**Exhibition of State Significant Development Application, Staged Commercial  
Precinct, West Hoxton (SSD 6407)**

TfNSW provides the following comments on the above development application.

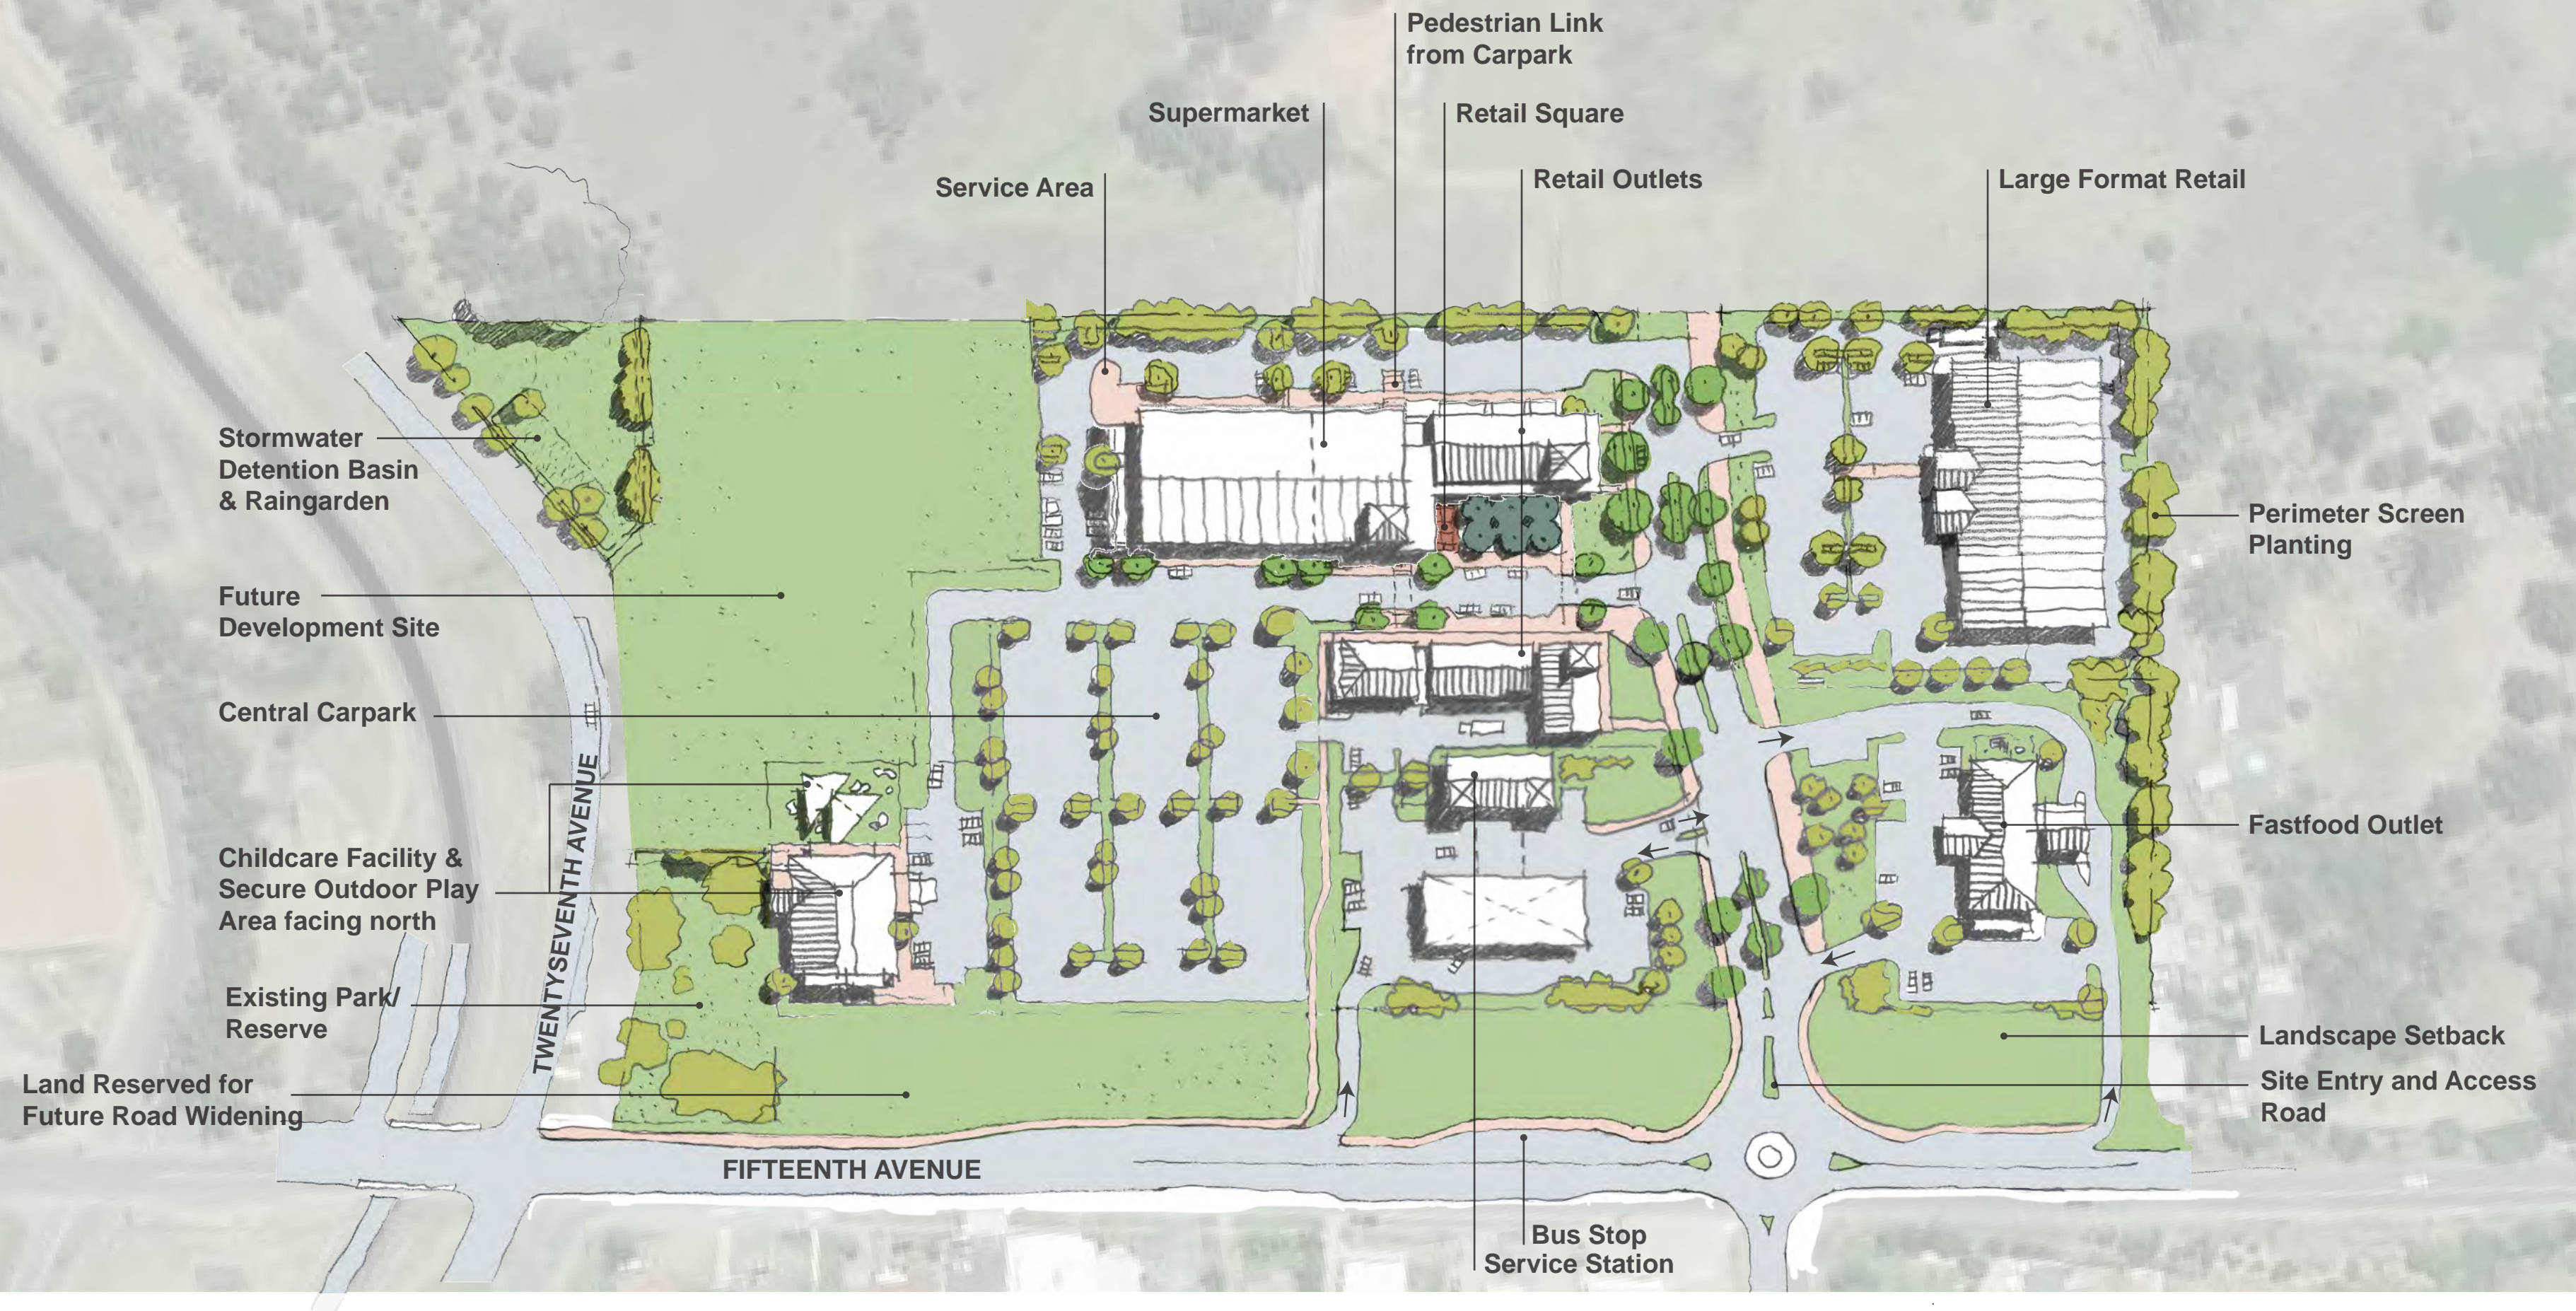
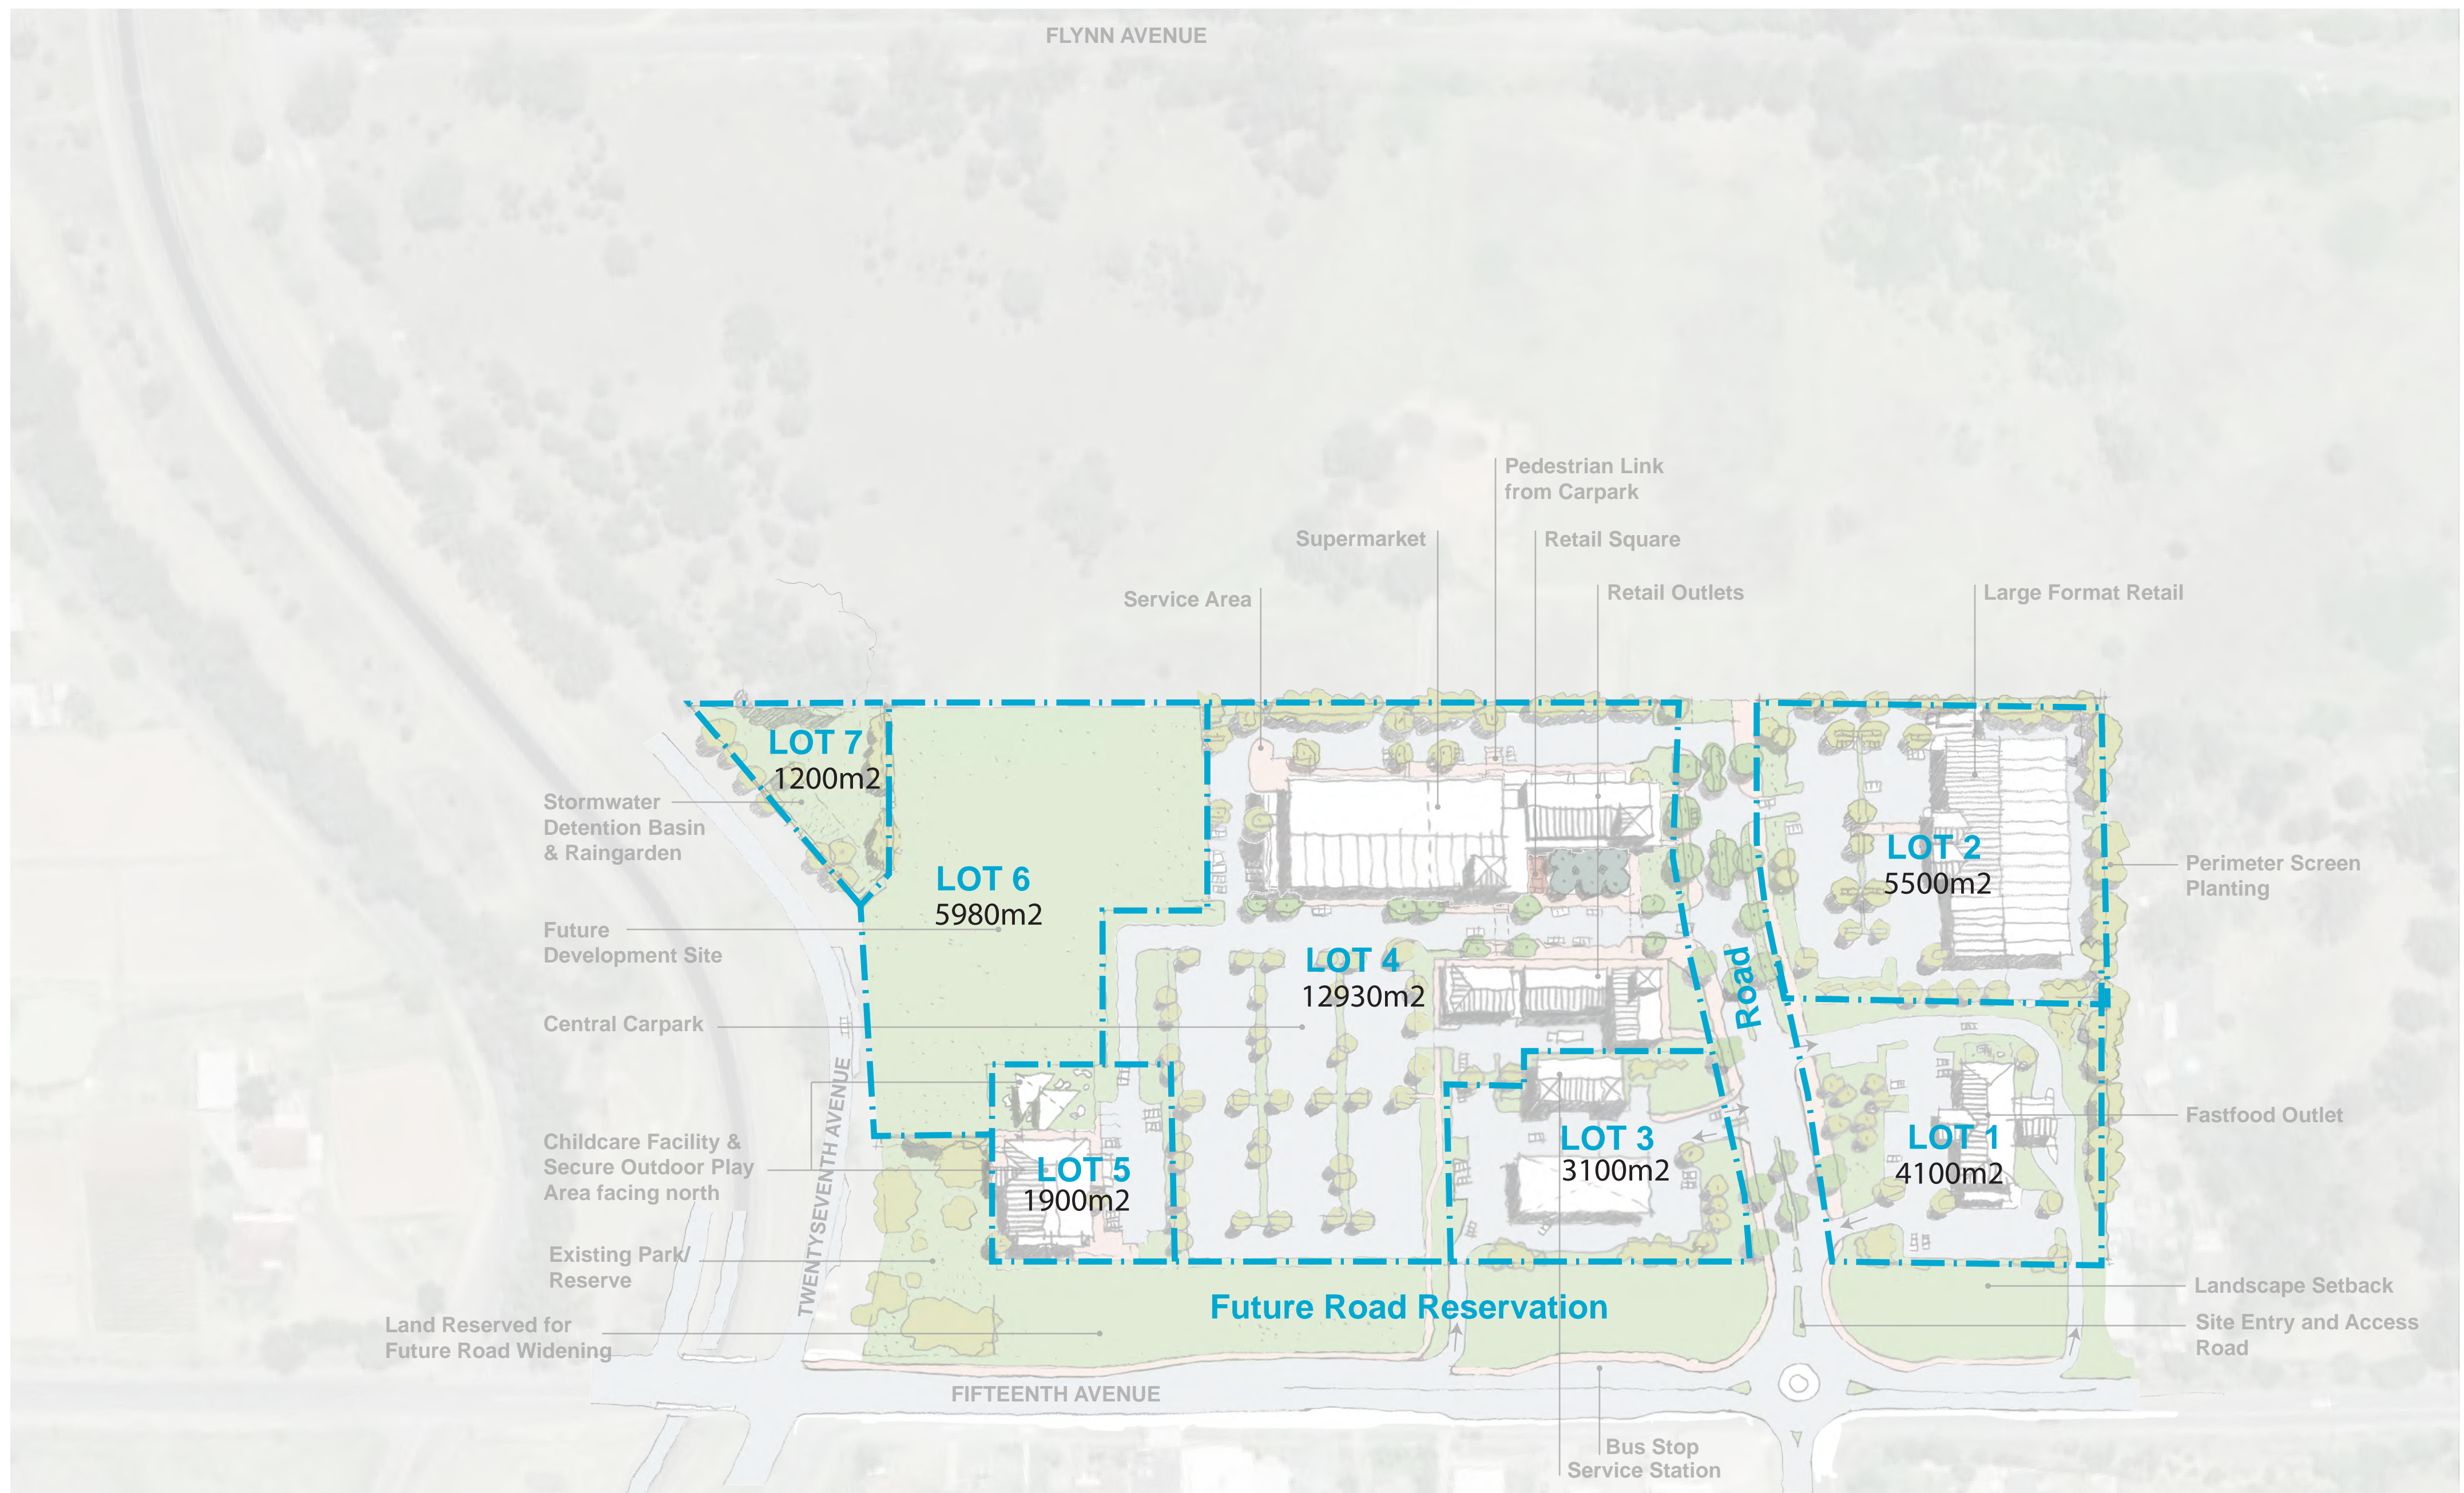
The Traffic Report states that a 40m wide reservation will be provided for Fifteenth Avenue road upgrade. However, a 40m wide reservation is not adequate for a potential BRT Route as identified in the *Sydney' Bus Future*. TfNSW requests that the proponent be conditioned to consult with TfNSW and Roads and Maritime Services to obtain the details of reservation area for Fifteenth Avenue to accommodate a BRT route.

TfNSW requests that the proponent provides safe pedestrian crossing facilities be provided across Fifteenth Ave connecting bus passengers on the southern kerb bus stop to the site and vice versa. The bus stop on the southern kerb of the Fifteenth Ave should be enhanced to ensure a bus could safely pull into and out of the stop. The design for the new bus stop should consider an environment of increased traffic and a new roundabout, including the provision of adequate seating necessitated from the proposed development.

TfNSW requests that the proposed roundabout at the Fifteenth Avenue/the proposed access be designed to accommodate the swept path of a 14.5m non-rear steer bus.
